Our ref: OUT22/20722

Subject: Tallawang Solar Farm (SSD-23700028) - Environmental Impact Statement (EIS)

Detailed advice to DPE Planning & Assessment regarding the Tallawang Solar Farm (SSD-23700028) - Environmental Impact Statement (EIS)

FIGURE 2.1

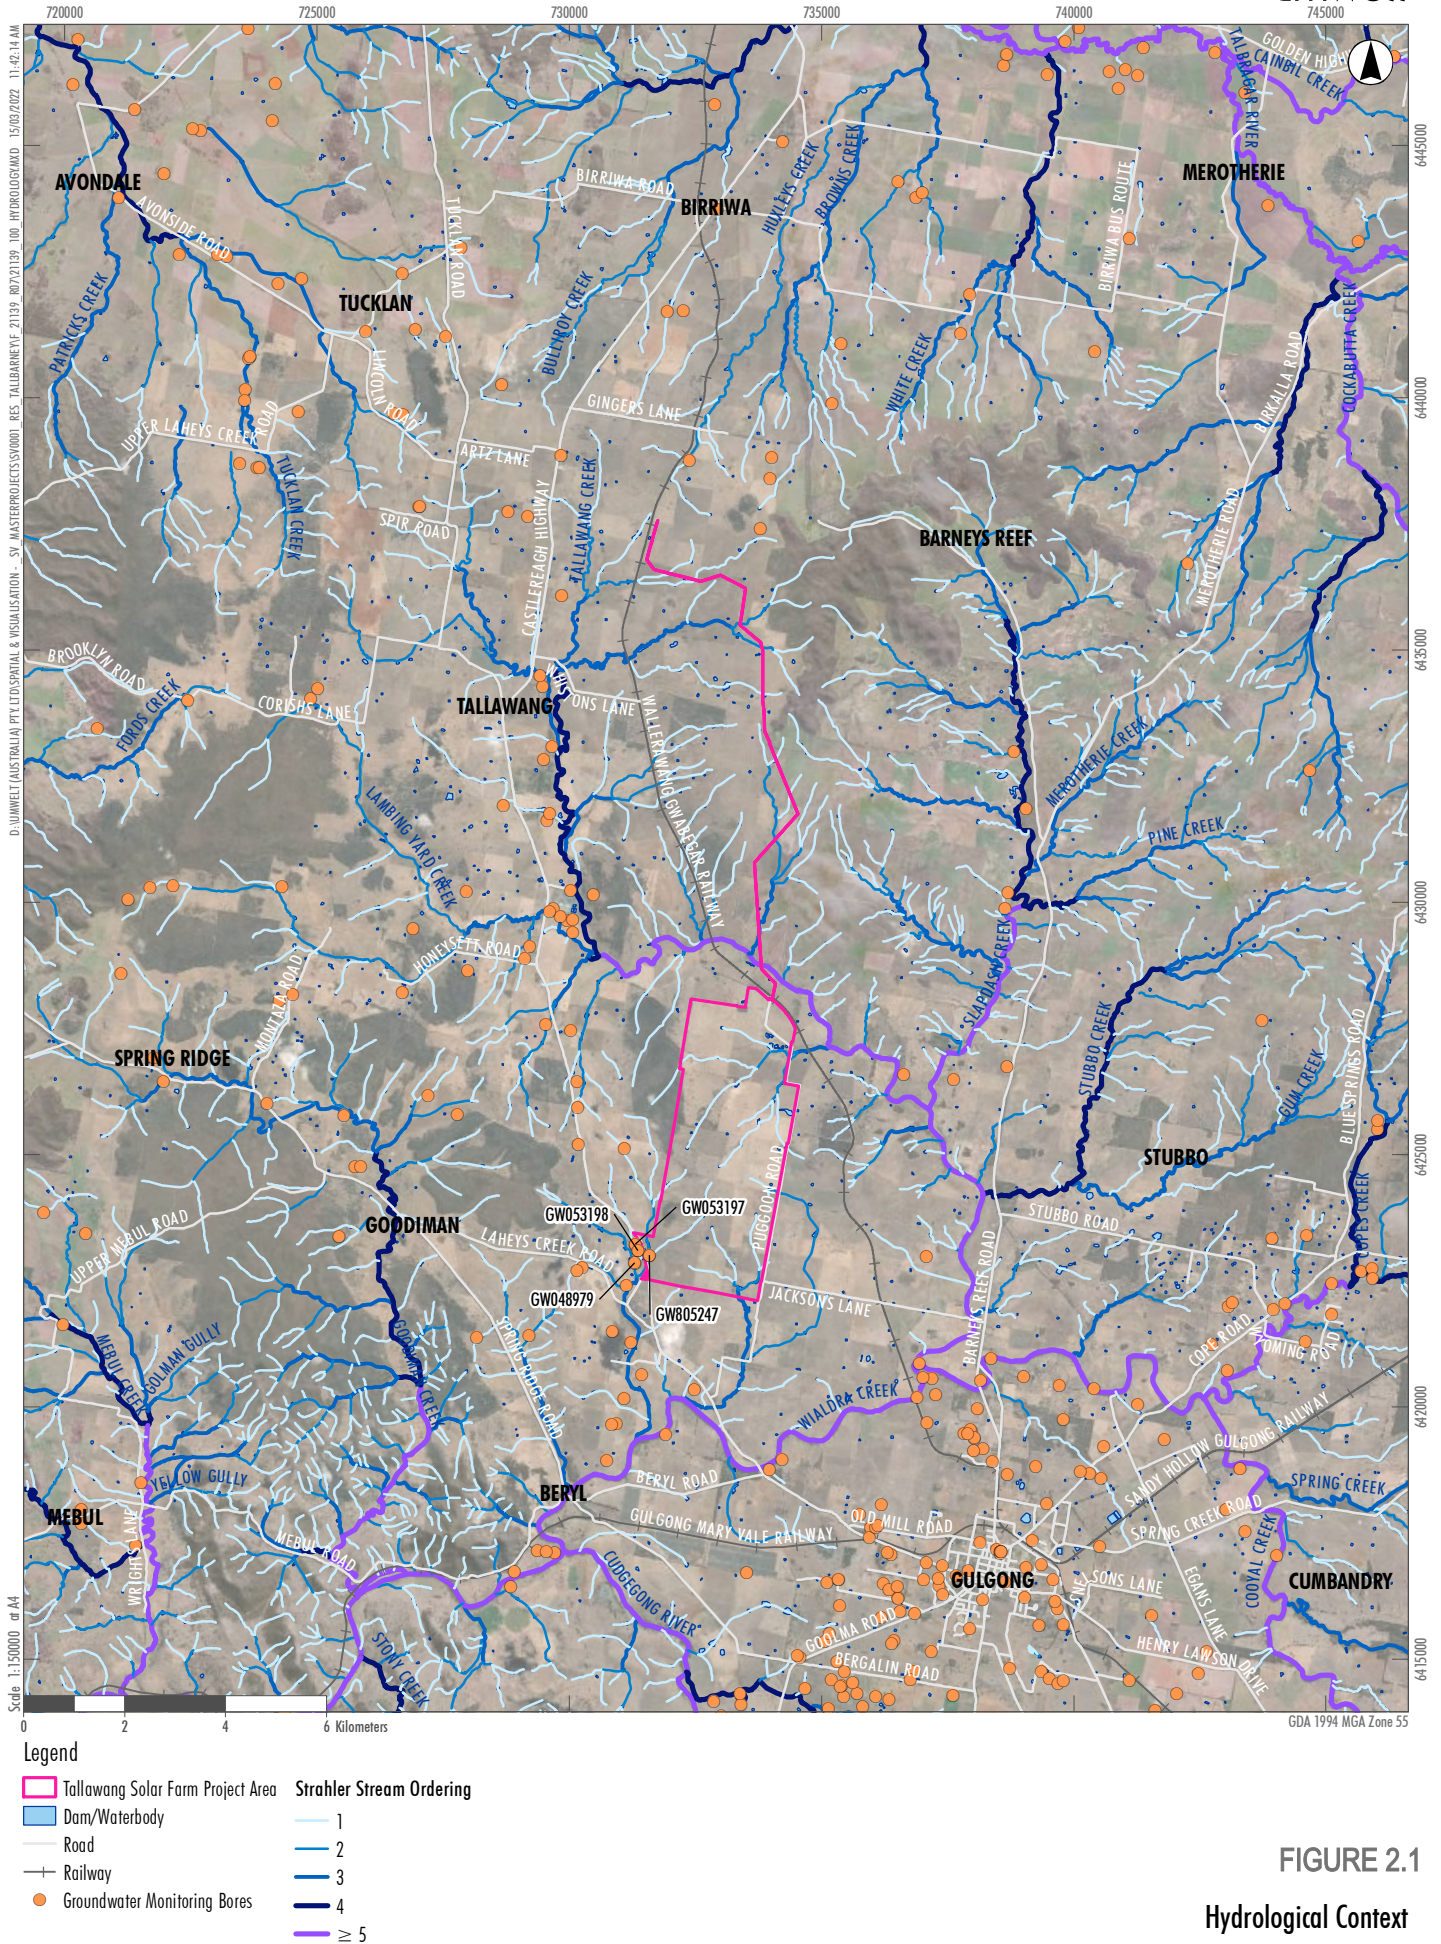
The proponent should confirm that the 2nd order watercourse in the south eastern part of the site has been provided with a setback in accordance with the Guidelines for Controlled Activities.

The EIS notes the setback of 40m from watercourses with biodiversity values. While this generally appears to have been applied, confirmation is requested that a setback for the 2nd order watercourse in the south eastern part of the site has been provided in accordance with the Guidelines for Controlled Activities.
